Reference: H09-0244-25 **Date of Decision:** 30th April 2025

Location: Westholme 32 West End Holbeach Spalding

Description: Conversion of existing basement to create 1 flat

South Holland District Council hereby give notice that this application has been REFUSED for the above proposal for the following reason(s):

DRAWING NUMBER | LDC4632-20

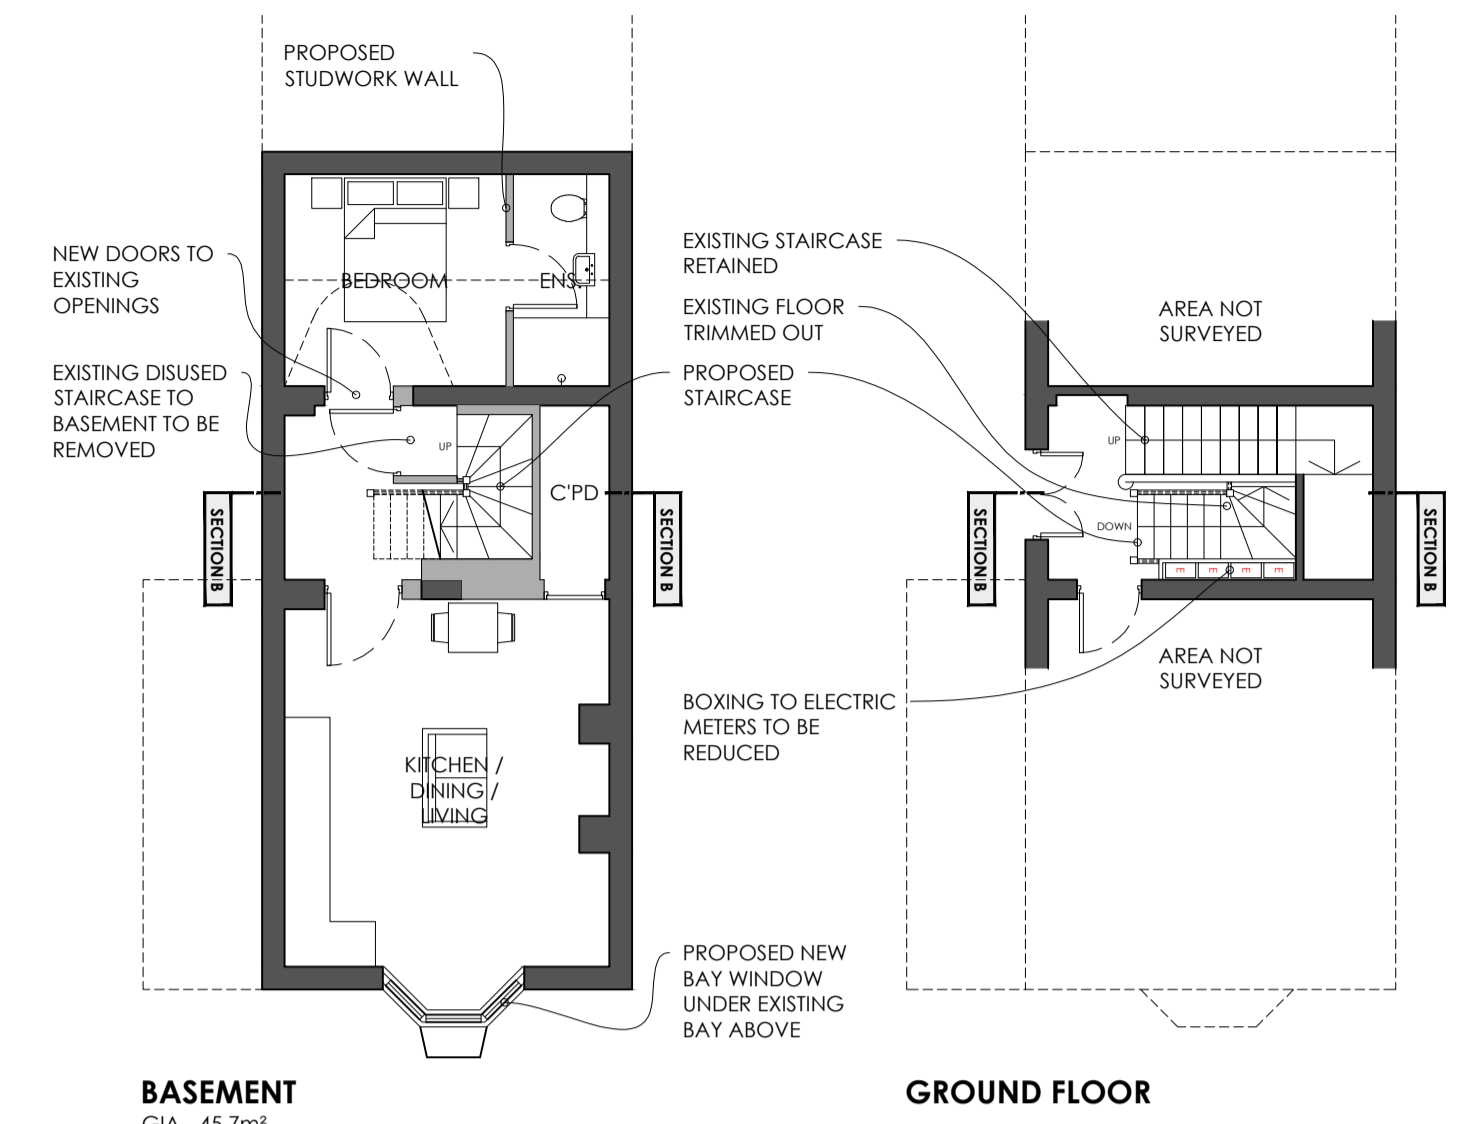
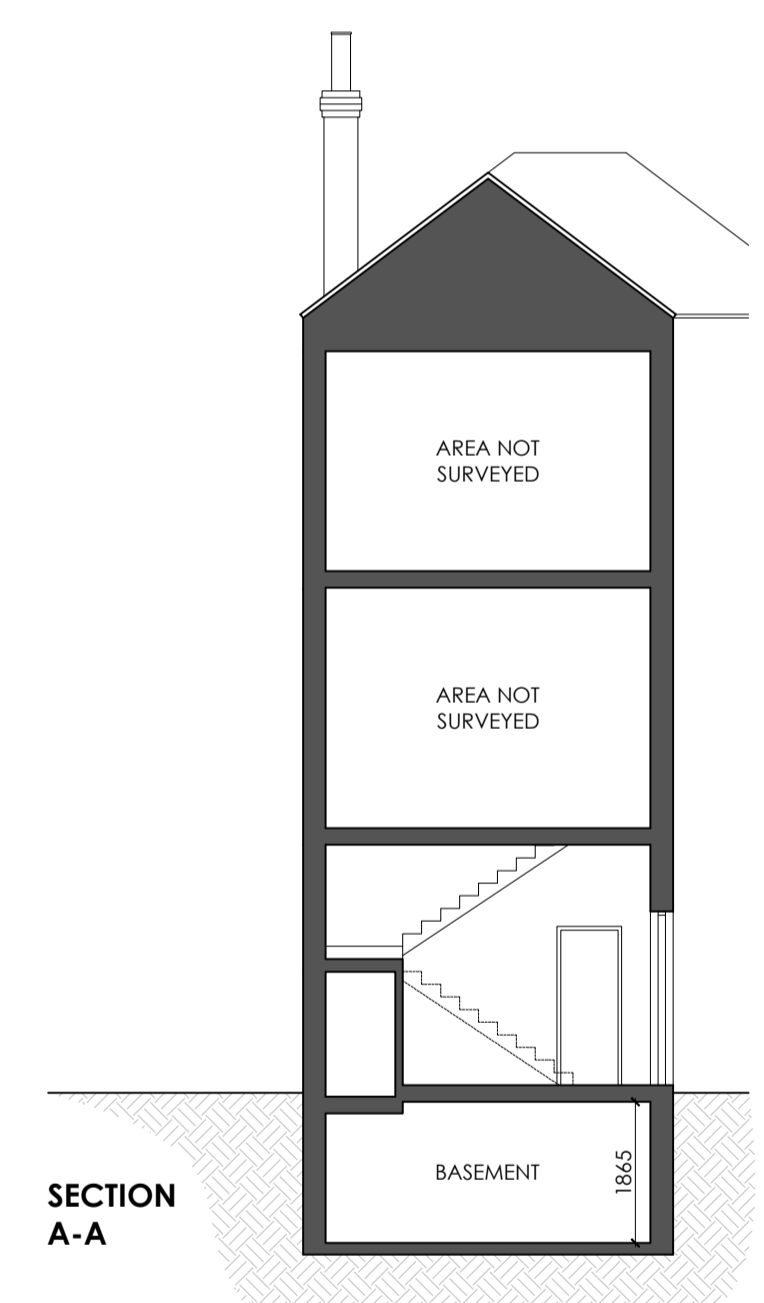
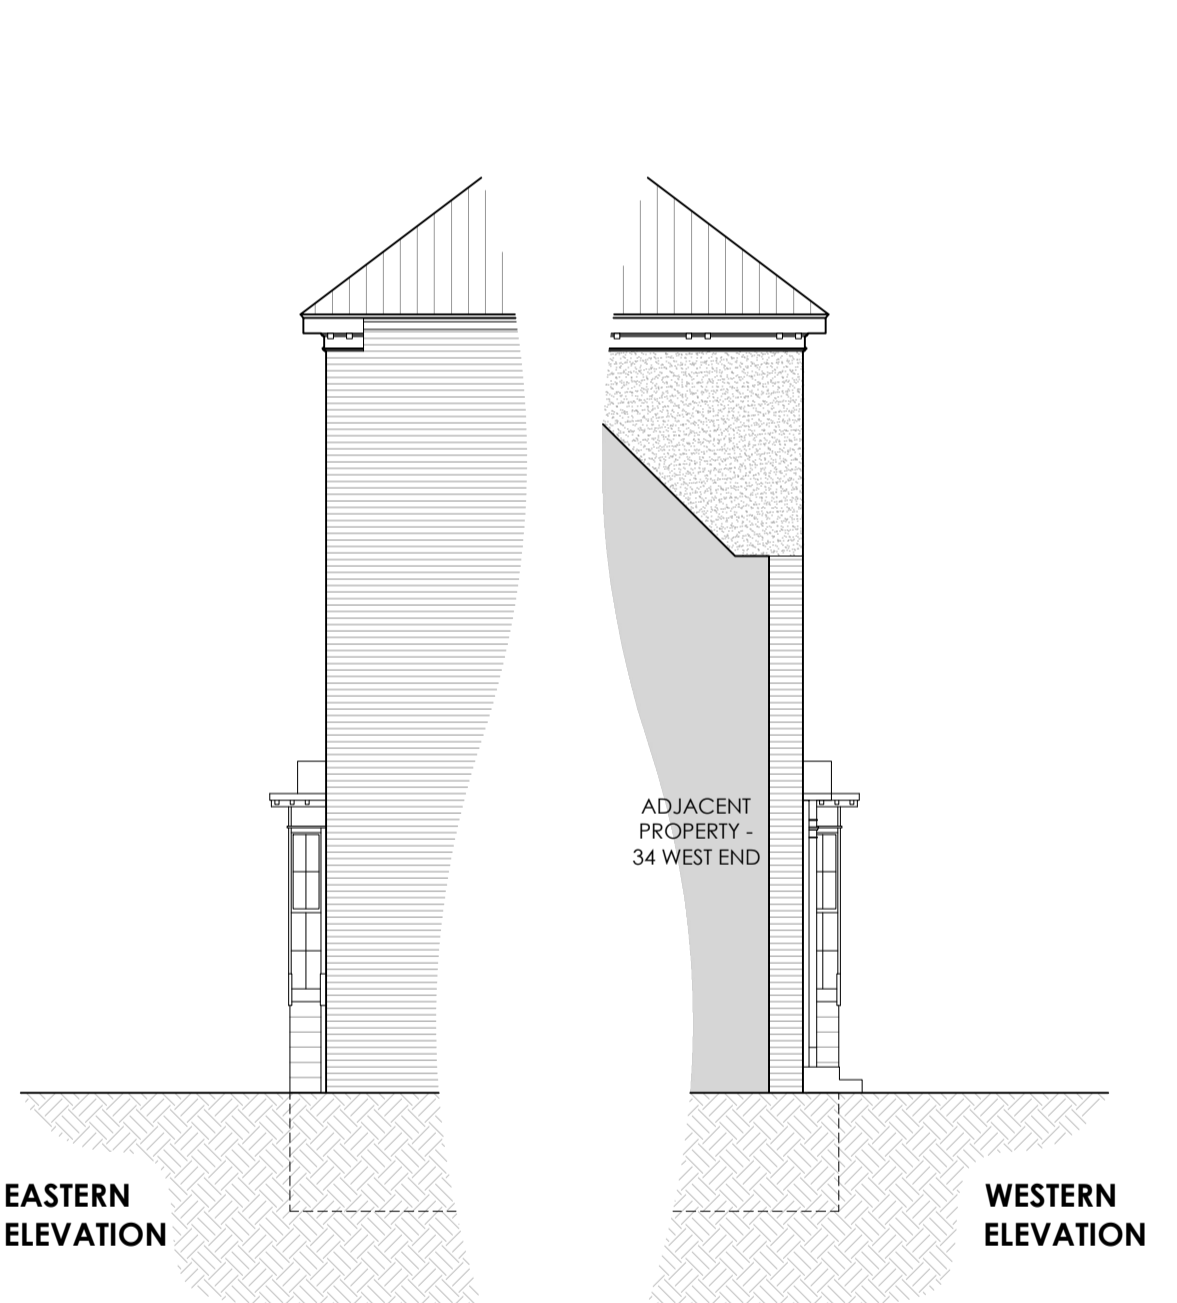
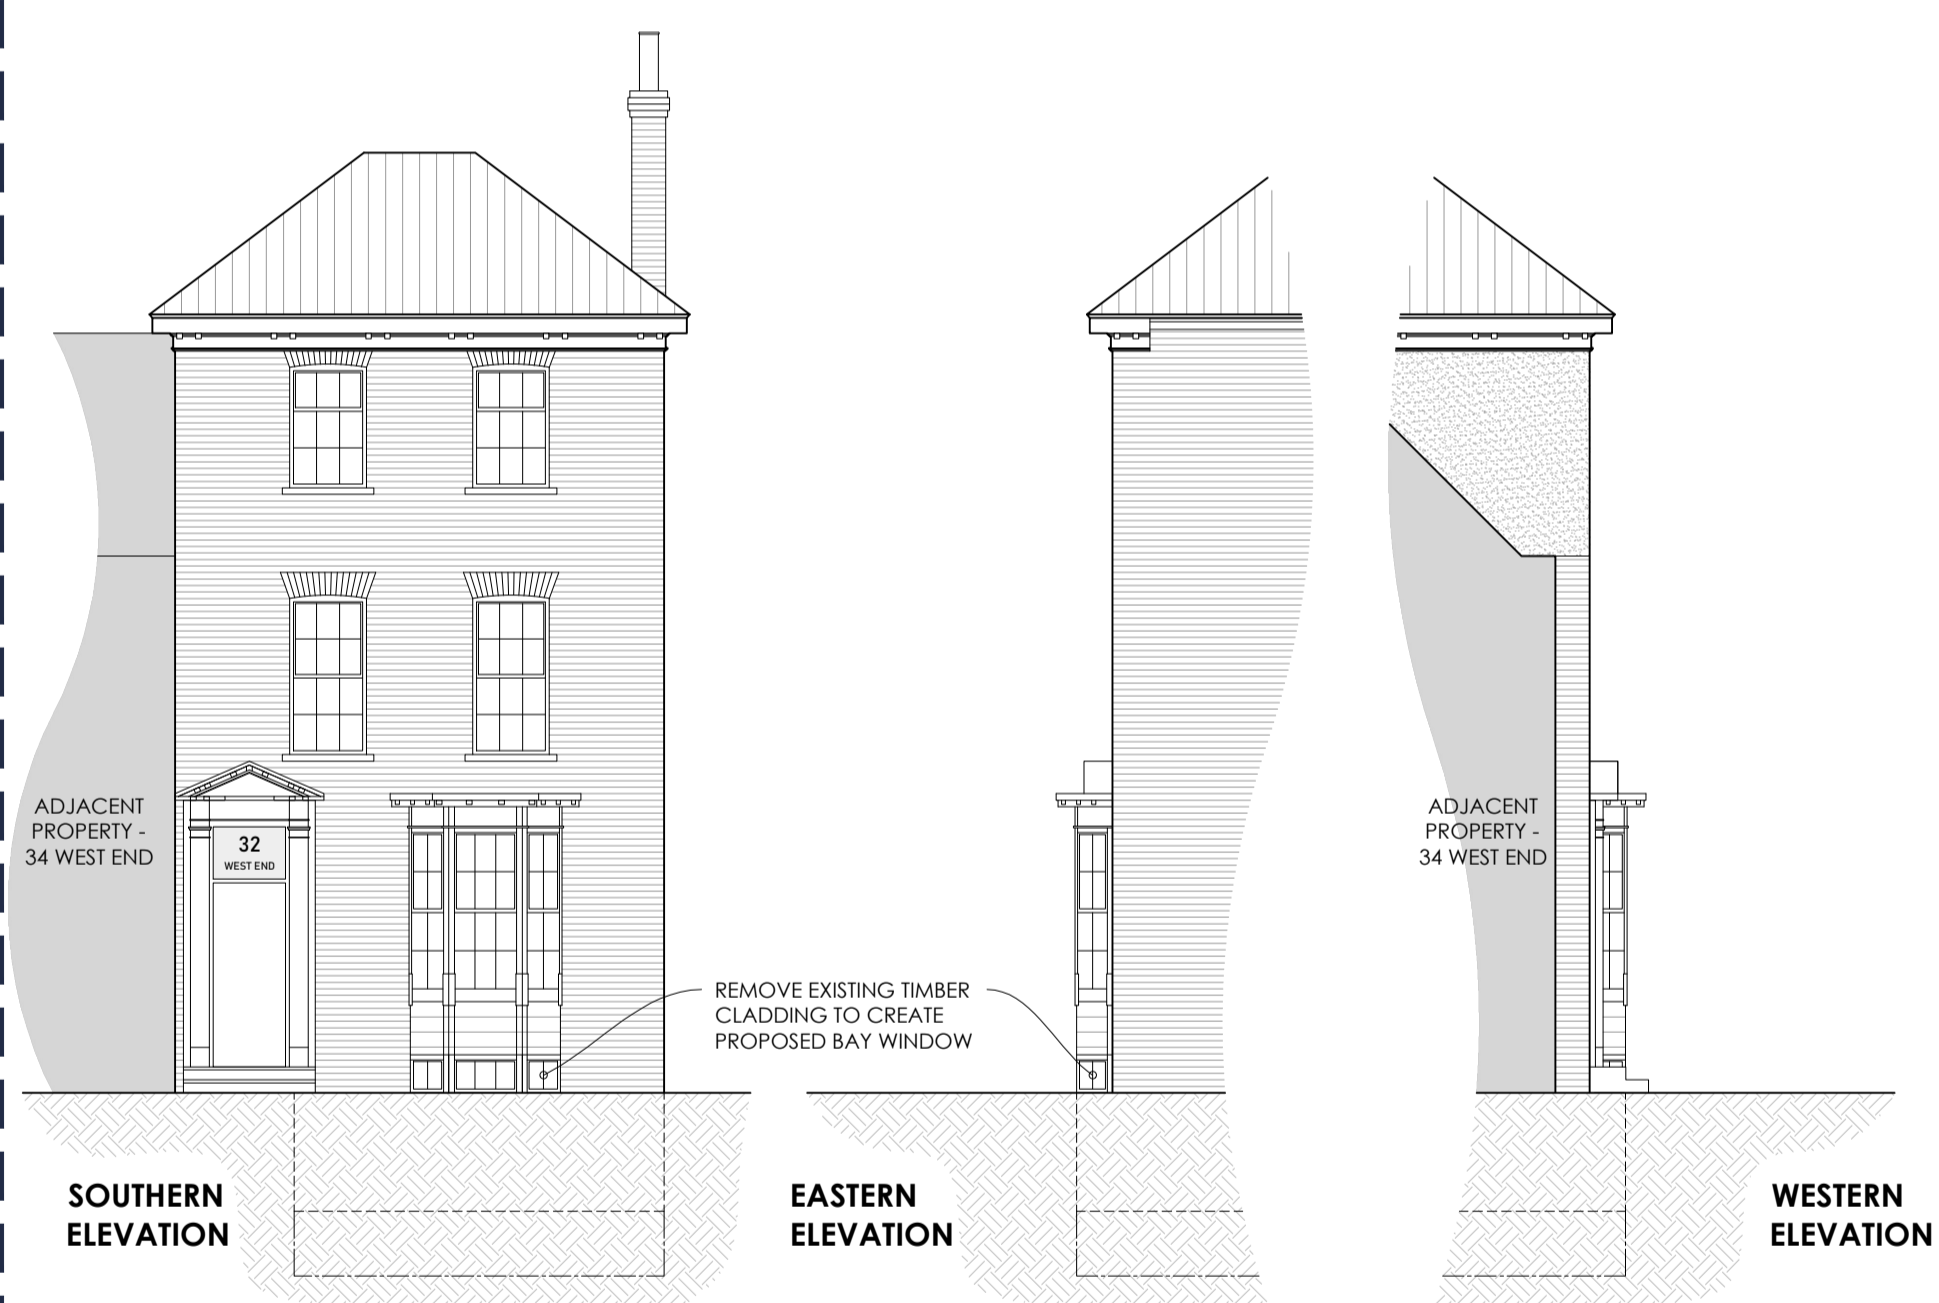
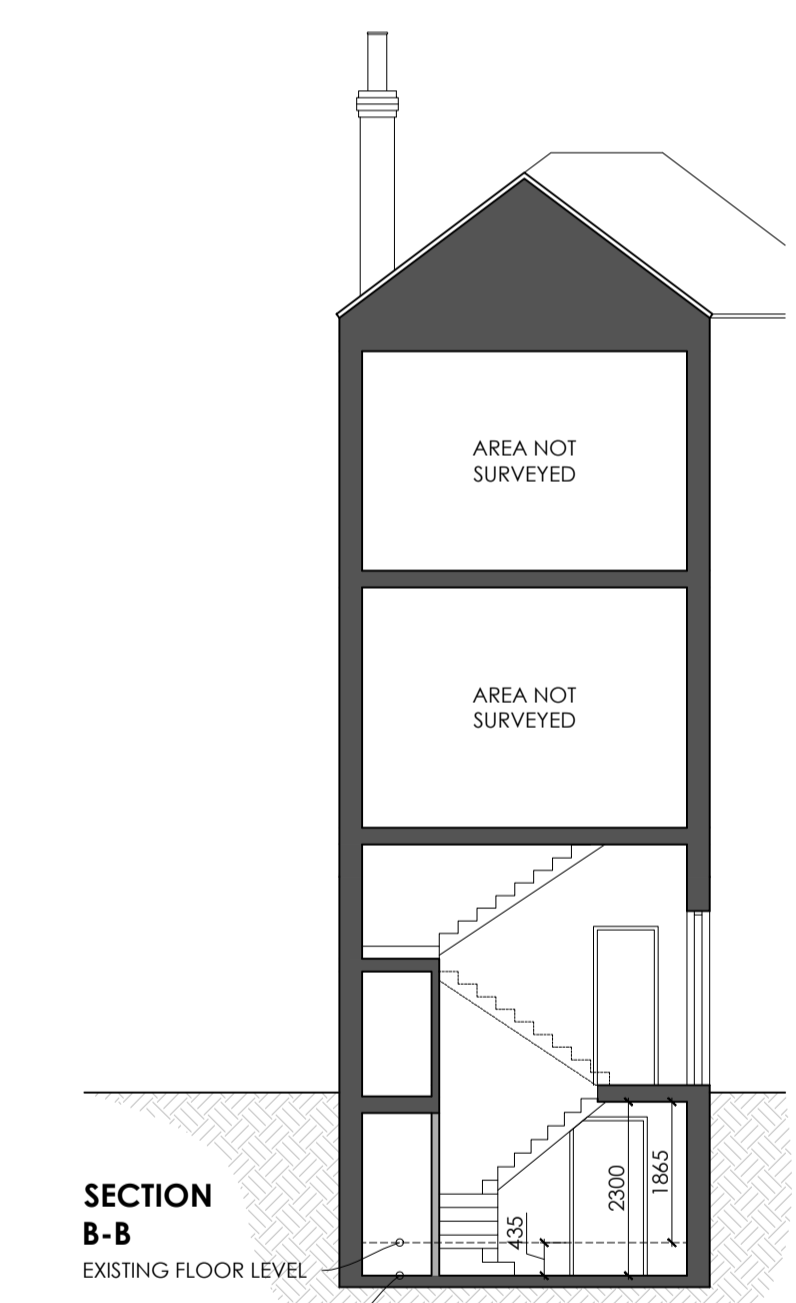
- 1 The proposed flat would be served by only one window, at the front of the building. It is considered that the provision of one window would not provide enough natural light and ventilation for future occupants. Furthermore, there would not be a decent outlook from the flat for future occupants, as most of the window faces onto a blank elevation. As such, the proposed development would result in a poor standard of living.

- 2 It is considered that the proposal would not accord with Policy 21 (namely parts 7 and 8) of the South East Lincolnshire Local Plan (2019). Part 7 of the policy requires that "an adequate standard of residential accommodation and residential amenity is provided for future occupiers". It is not considered that a suitable standard of residential amenity would be achieved. Furthermore, Part 8 of the policy requires that "adequate provision is made for the communal gardens and amenity areas". No external amenity space appears to be

available for the proposed flat and as such, the proposal would not accord with part 8 of the policy.
